**Item No.**                      **Report of the Head of Development Management and Building Control**

**Address:**                      11-17 VICTORIA ROAD RUISLIP MANOR

**Development:**                Erection of ground floor rear extension and three storey extension above existing commercial parade to provide 7 residential units (Class C3) (2 x 1-bed, 2 person units, 4 x 2-bed, 3 person units and 1 x 3-bed, 5 person unit)

**LBH Ref Nos:**                **72104/APP/2025/1096**

Proposed Roof Plan
Scale 1:100

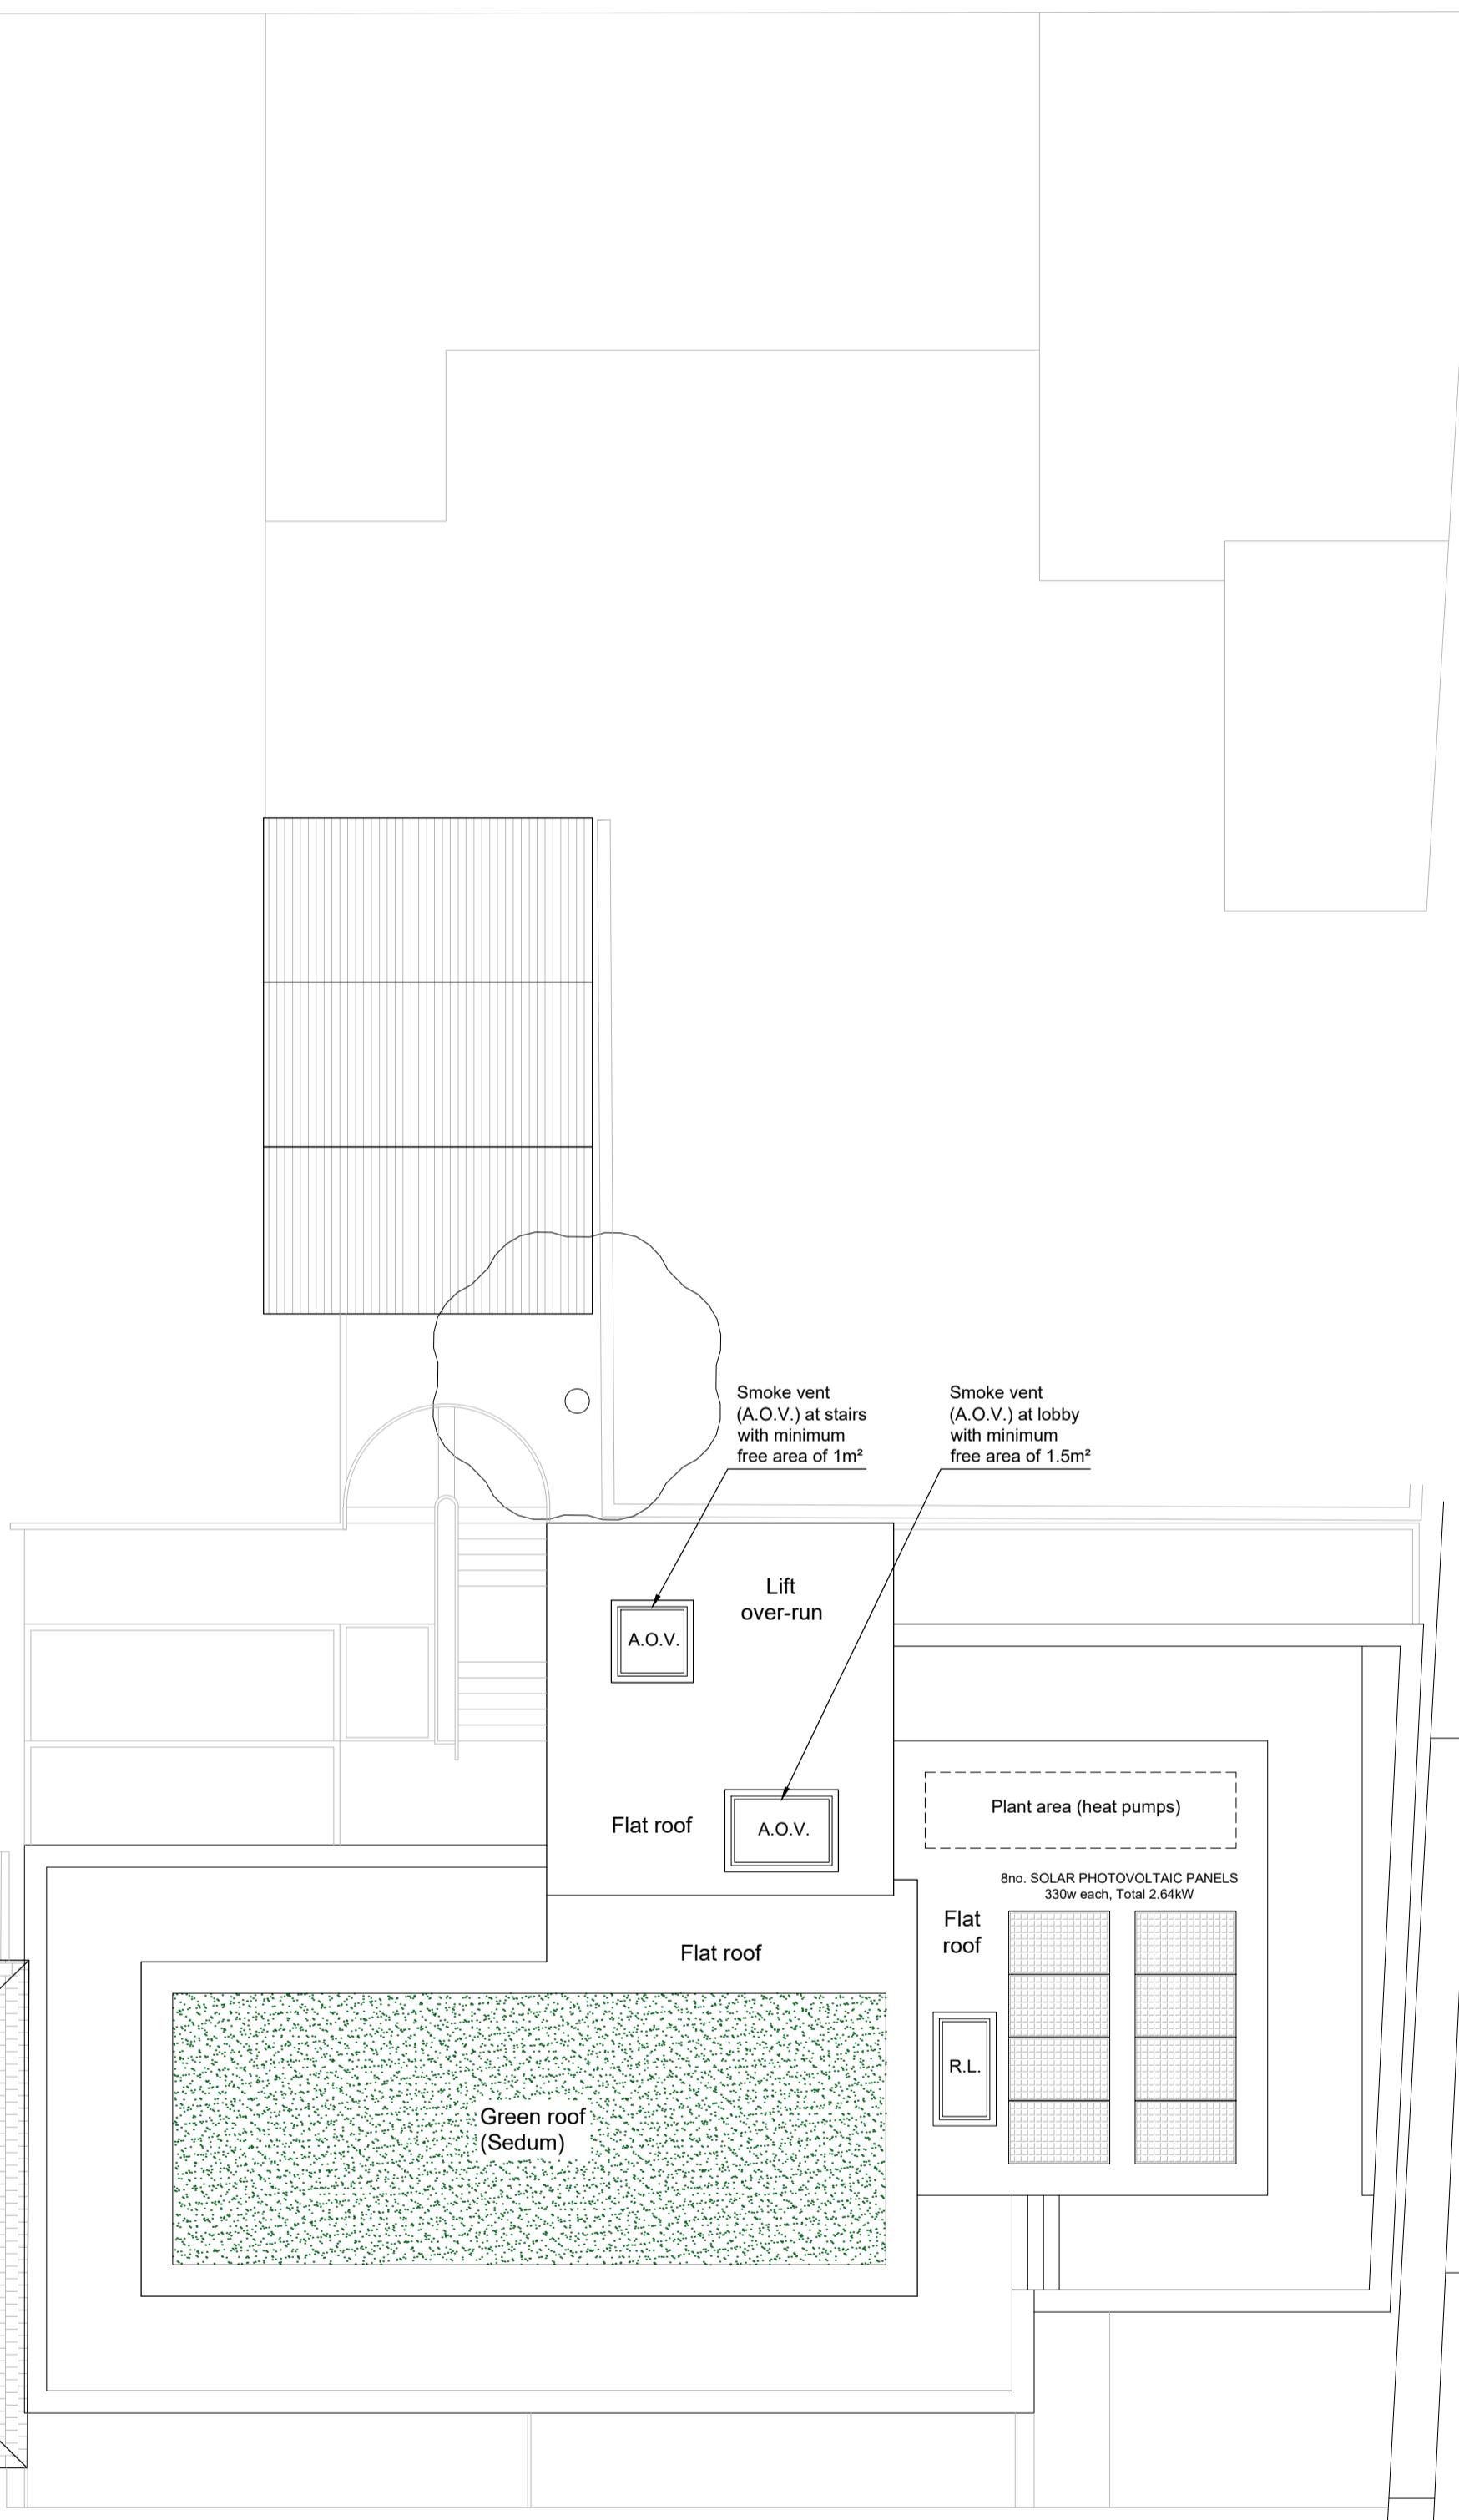
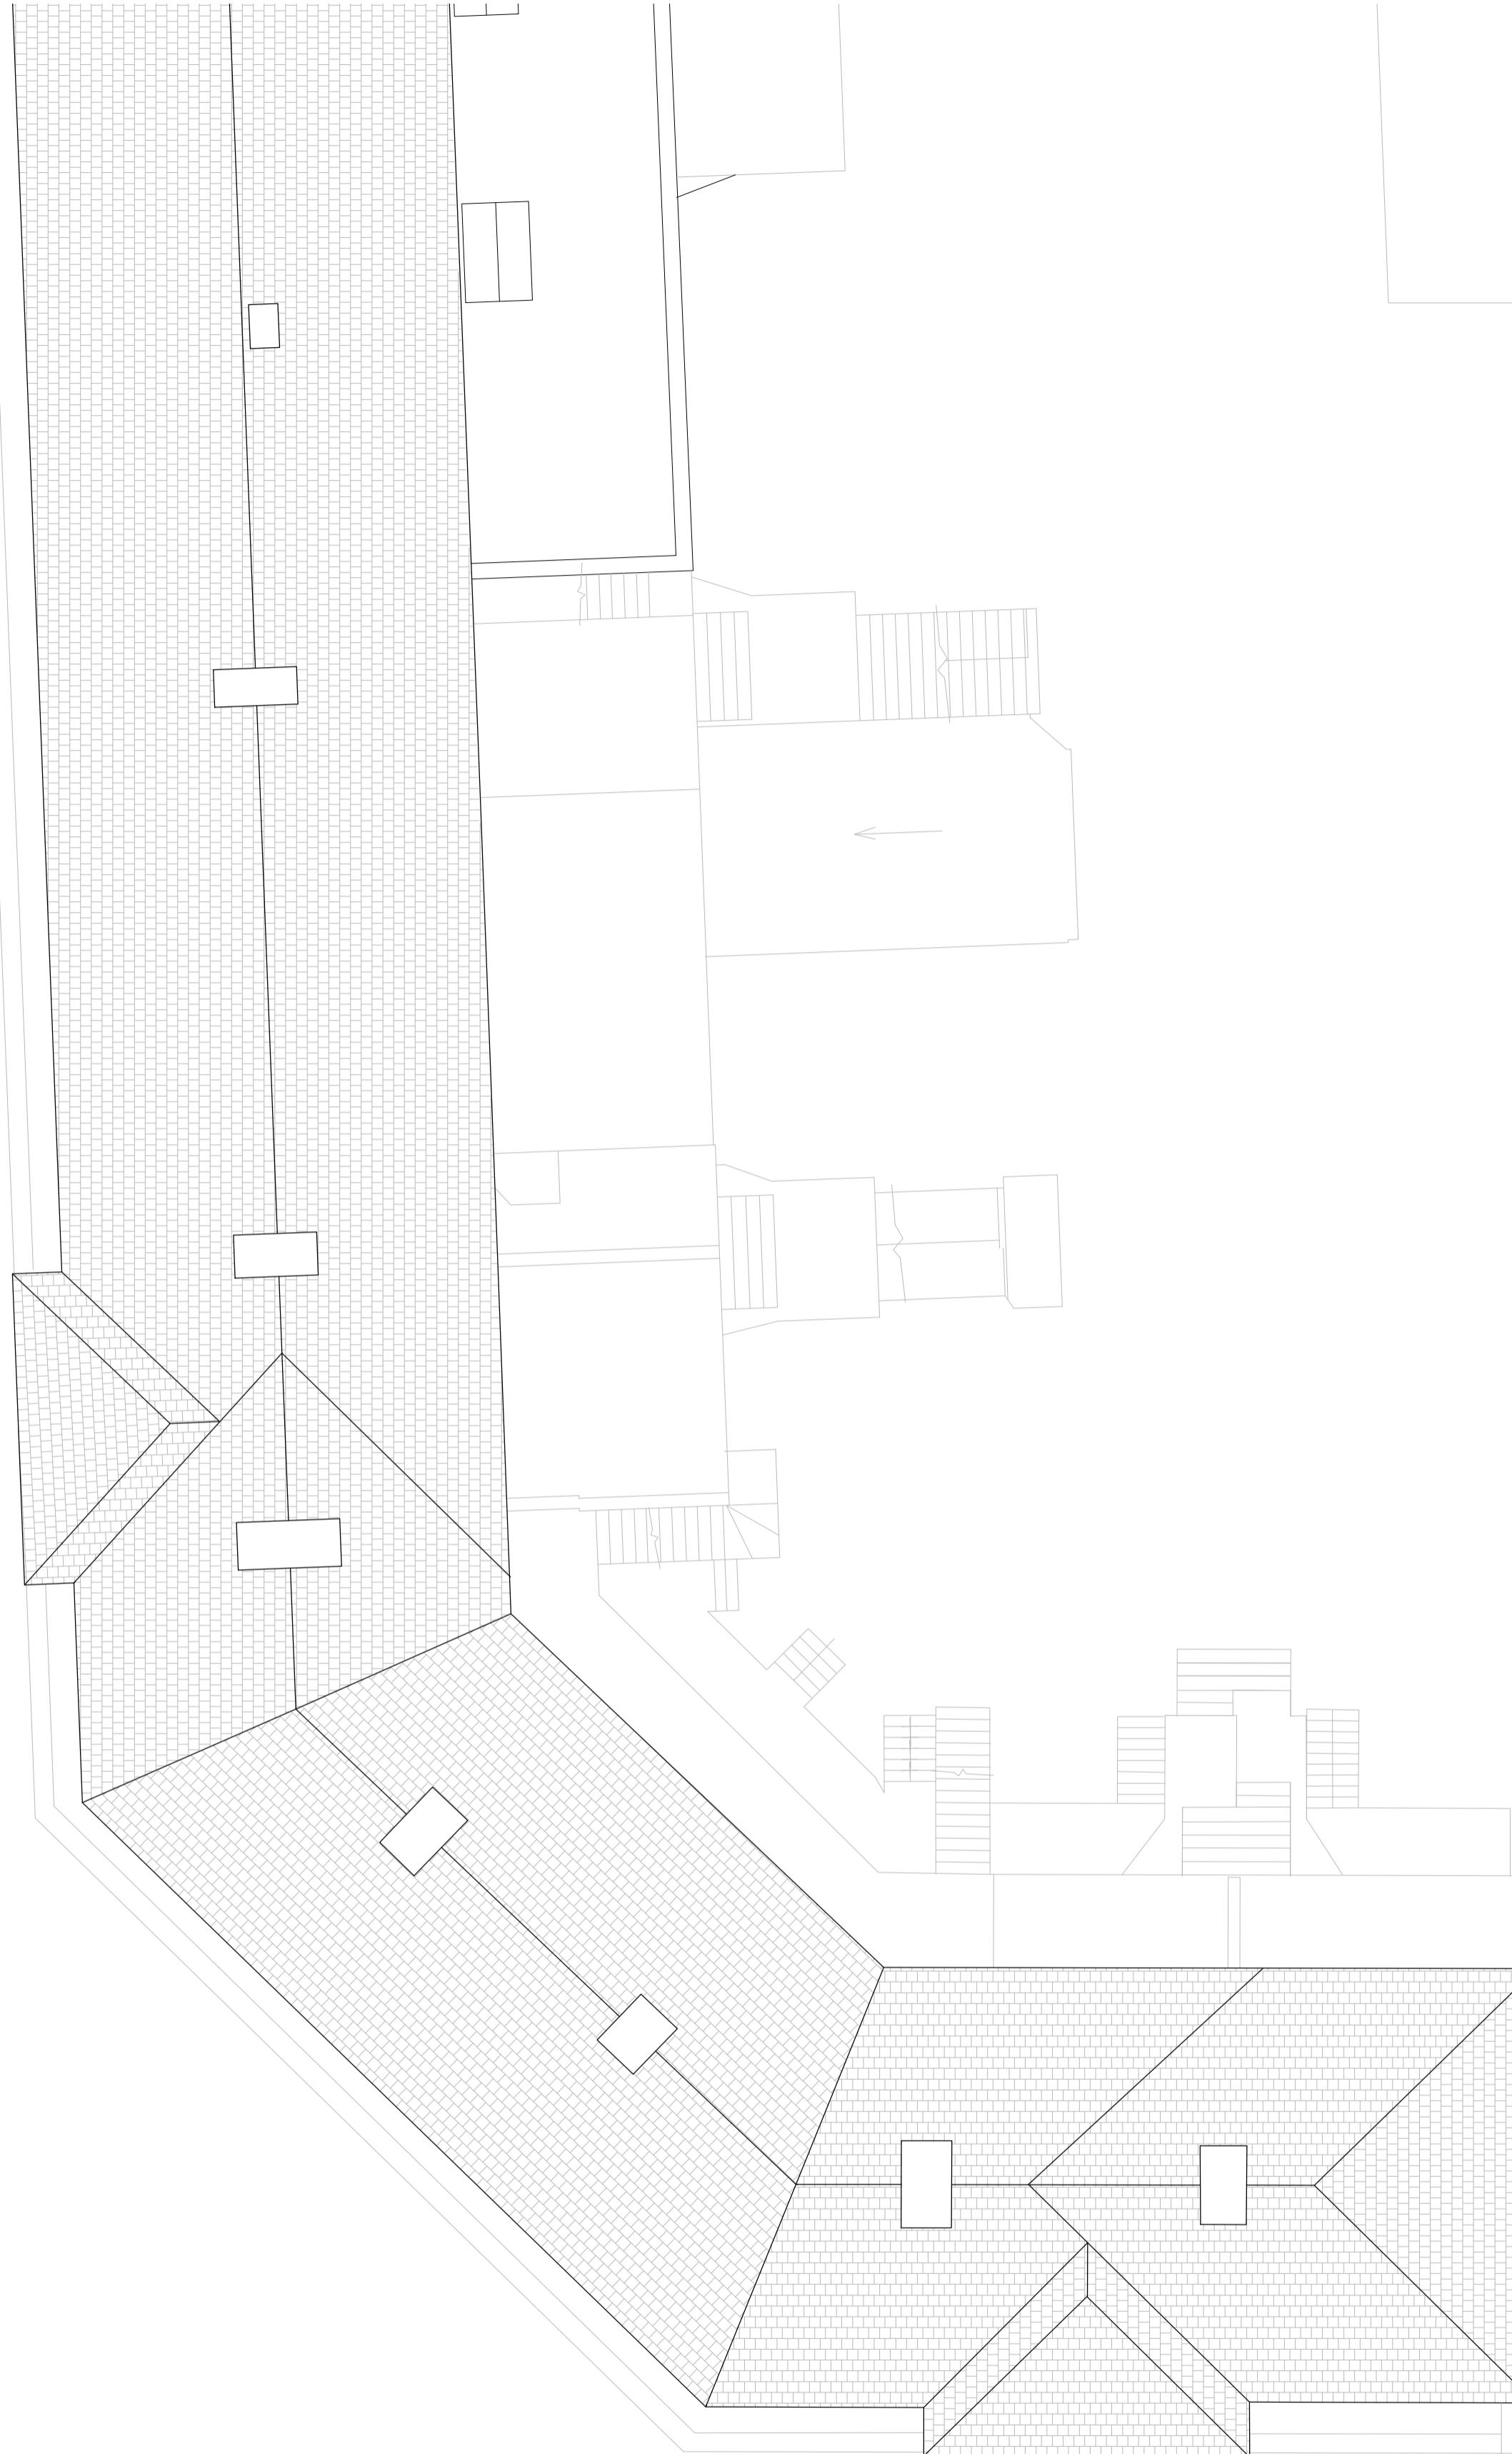
The proposed roofscape of the building should aim to reflect and build upon the positive local character adjacent to the application site. The proposed roofscape does not achieve this, as it is a series of flat roofs with a lift over run and AOV, which creates an overly complicated and uncharacteristic roof form. A better relationship between the existing and proposed should be created through the use of a more appropriate pitched roof form, which would provide better visual balance to the street.

Proposed Front Elevation
Scale 1:100

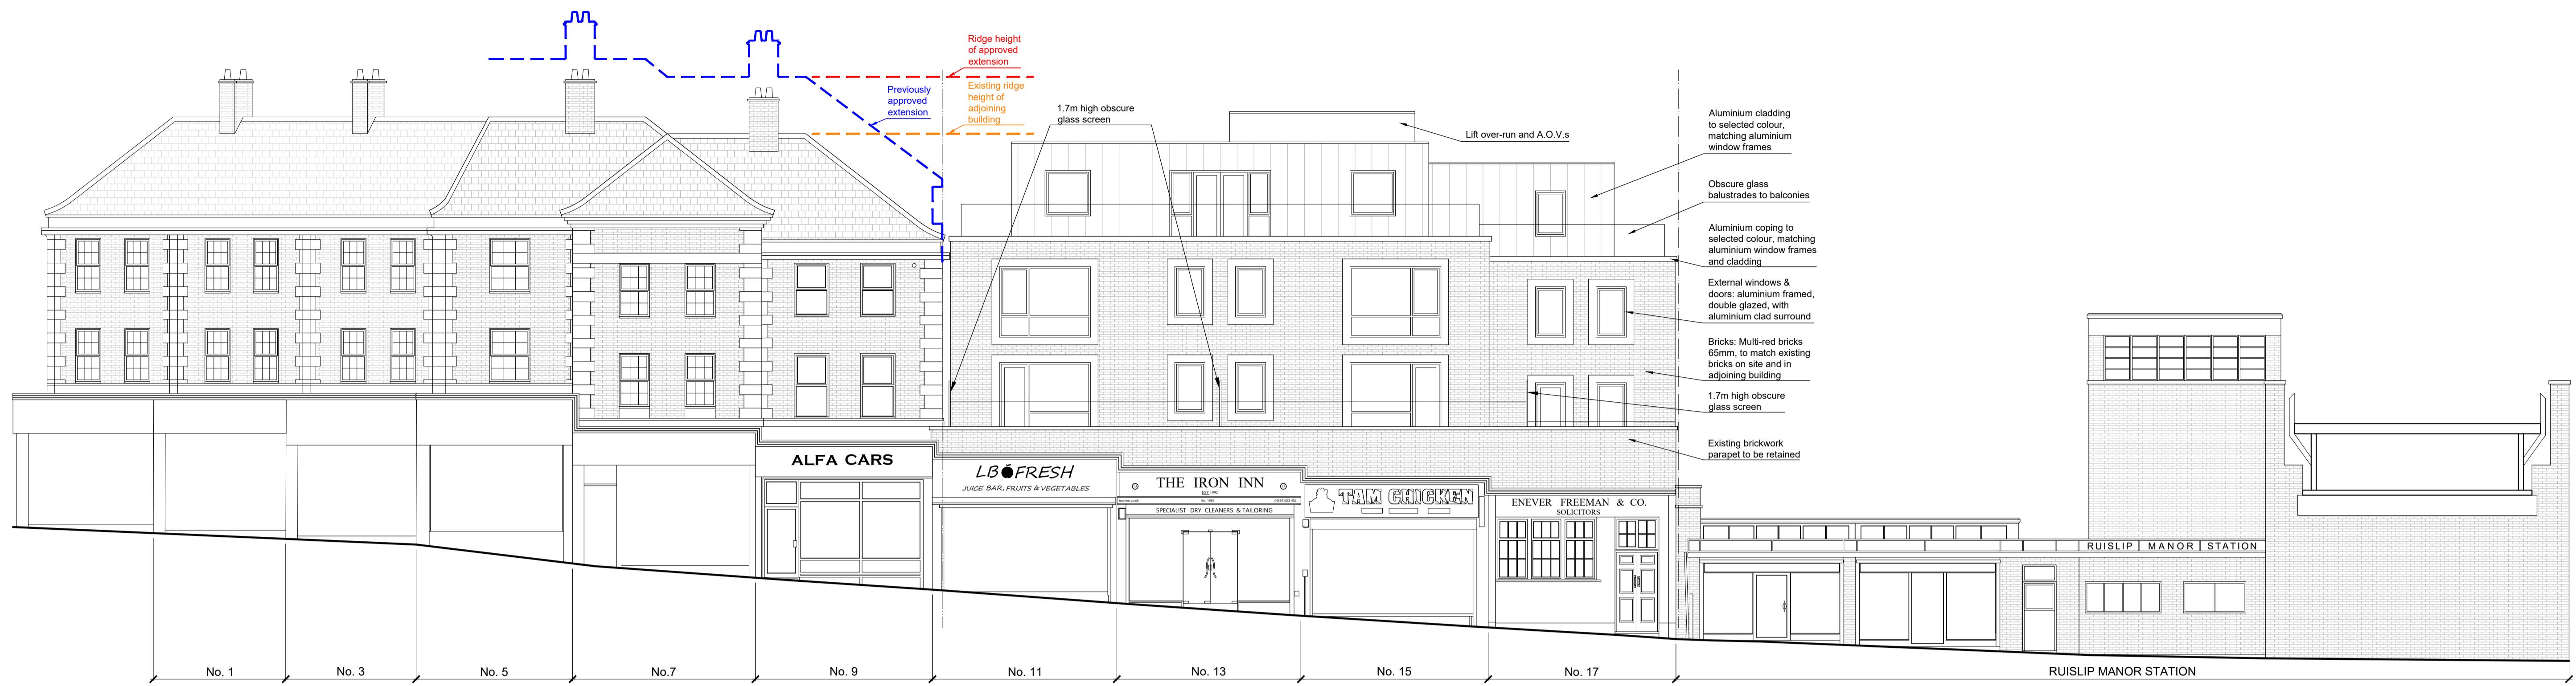
The proposed development, by reason of its siting, scale, massing, and poor overall design, would result in a discordant and unsympathetic form of development that fails to respect the setting, character, and architectural integrity of the existing and attached building. The proposal is therefore contrary to Policy of the Hillingdon Local Plan: Part One - Strategic Policies (2012); Policies DMHB 11, and DMHB 12 of the Hillingdon Local Plan: Part Two - Development Management Policies (2020); Policies D3 and D4 of the London Plan (2021); and the National Planning Policy Framework (2024).

The current proposal needs to incorporate architectural detailing from the neighbouring building to make sure a visual coherence is kept within the street. The street elevation currently does not keep the same proportions and rhythm as the adjacent building which, despite its height, has a strong vertical rhythm created by its architectural detailing through features such as regular, narrow grouped windows and stone quoining. The current proposed facade introduces more horizontality into the street scene which creates a confused architecture making the building look fragmented rather than balanced. The proposed window openings also lack a clear sense of order or grouping, comprising a series of different window sizes and shapes.
